**WELWYN HATFIELD BOROUGH COUNCIL
ASSISTANT DIRECTOR (PLANNING)**

DELEGATED APPLICATION

Application No: 6/2022/2811/ADV
Location: 15 Howardsgate Welwyn Garden City AL8 6BU
Proposal: Installation of x2 non-illuminated signs, 1 externally illuminated sign, retractable canopy, barriers at front of the restaurant and 1 externally illuminated projection sign (retrospective)
Officer: Mrs Sarah Madyausiku
Recommendation: Refused

Drawing title
Proposed Floor Plan

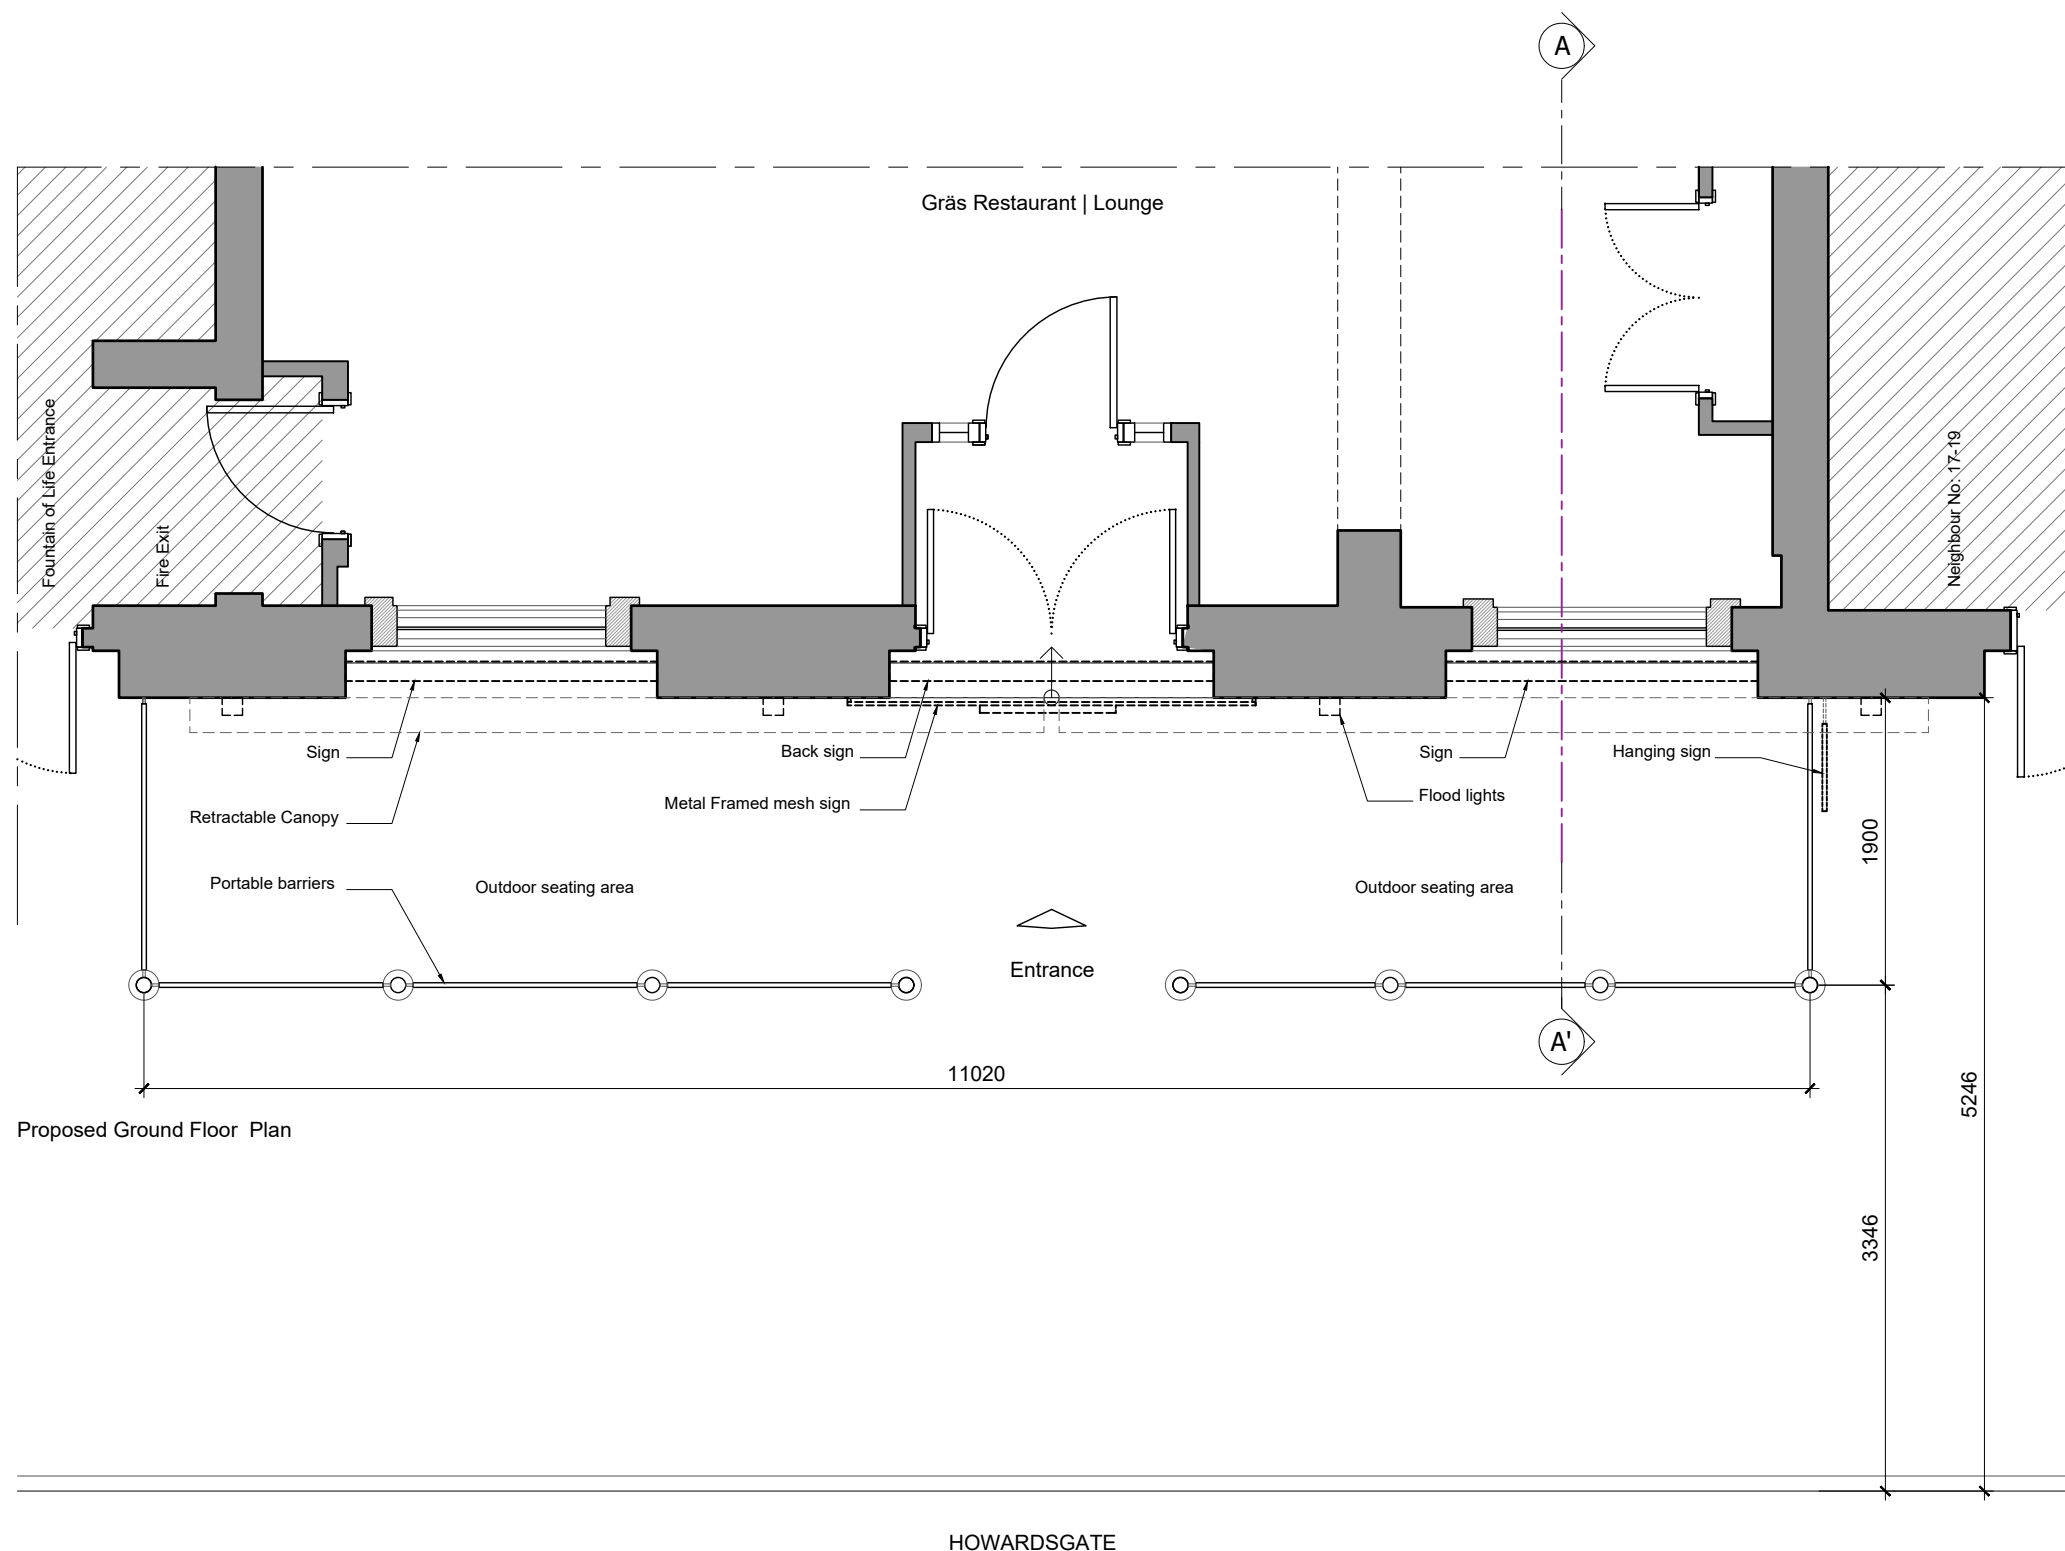
The footway width on the submitted plan is shown to be 5.246m and 1.9m is required for portable barrier/outside seating. The proposal would result in 3.346m wide unobstructed footway path. The relatively wide footway and the proposed portable barrier/tables and chairs would result in an unobstructed pedestrian path of more than 3m in width. Given there is a width of 3.346m for pedestrians to use, the proposals would not have any significant detrimental impact on pedestrian safety, flow, movement.

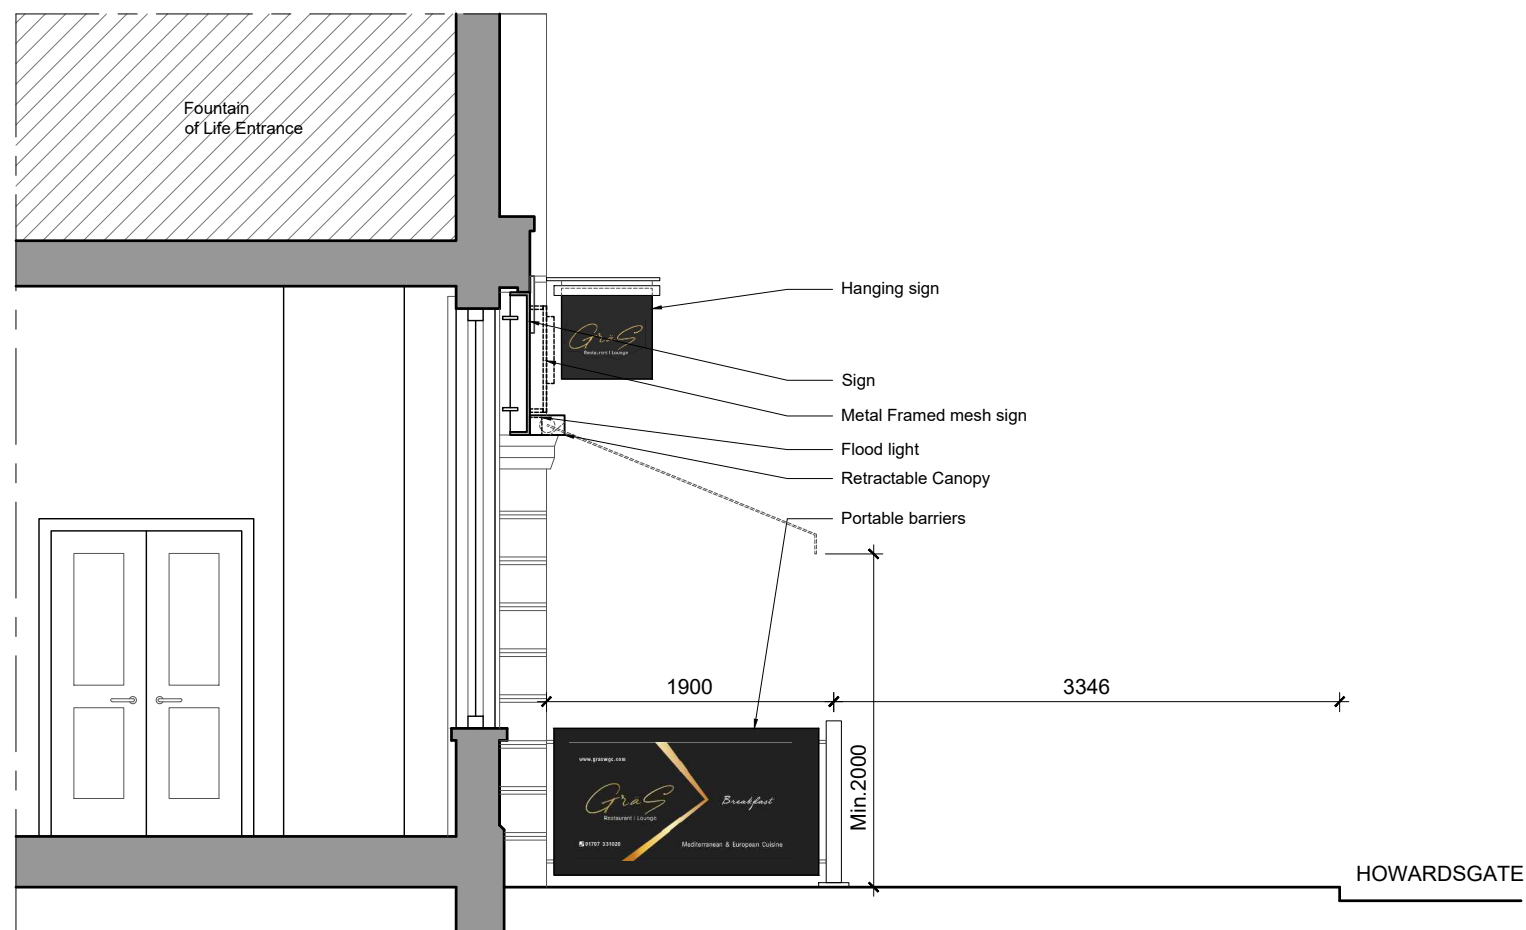
In addition, the awnings, which contain advertisements, have been installed across the frontage of the unit in a way that shows little consideration to the architectural features of the lower part of the building. Both when in the open position and when closed, the bulky frames and size of the awnings detract from the appearance and character of the building and Conservation Area.

Client	Mr Uluhan Genc		
Project	15 Howardsgate Welwyn Garden City AL8 6AL		
Scale	NTS	Date	06.02.2023
Drawn By	SA	Checked By	-
Project No.	Drawing No.	Revision	
SAA0014 - 23	A110	-	
Drawing title			
Proposed Portable Barriers

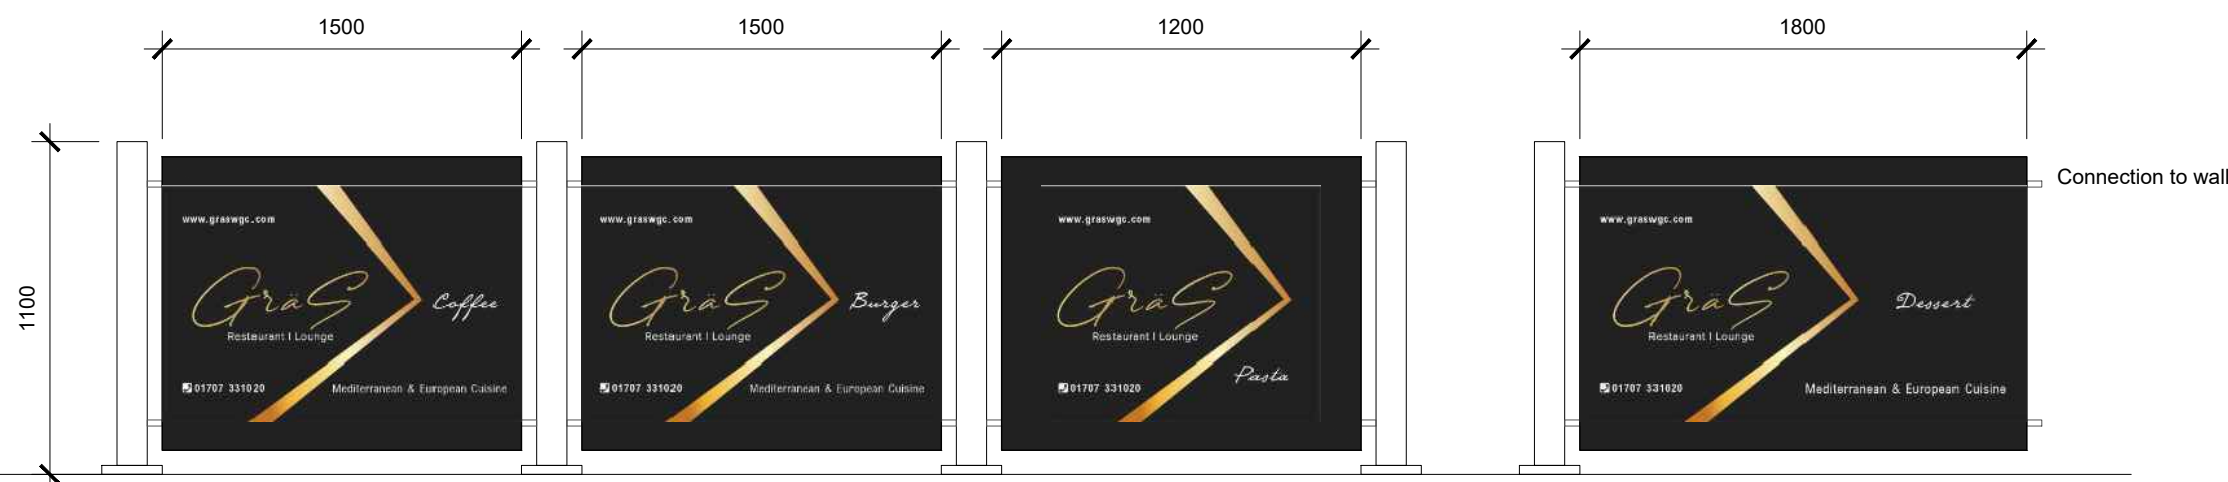
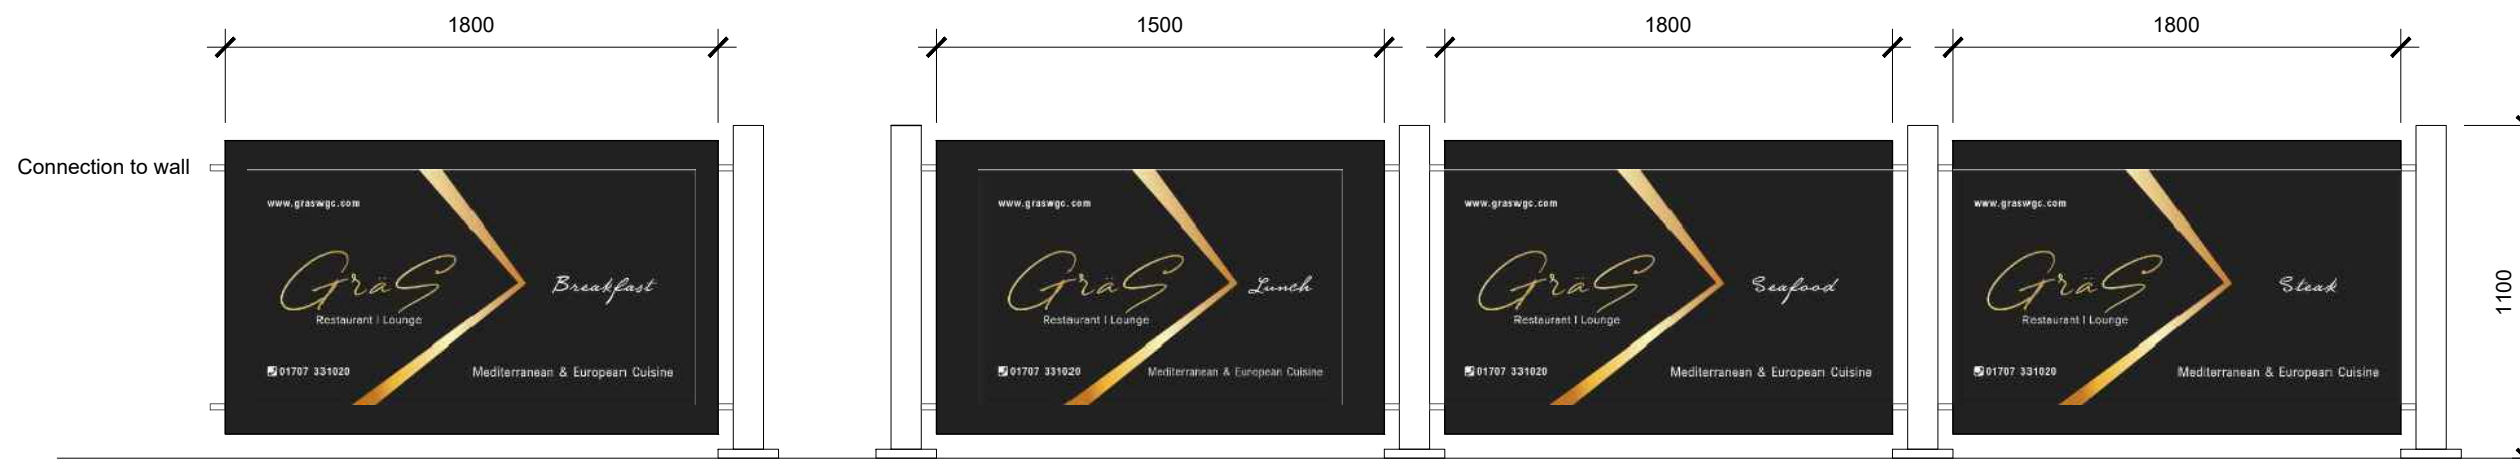
The projecting sign is large, but its design and method of illumination is not opposed. The barriers, that are moveable, do not harm the visual amenity of the area.
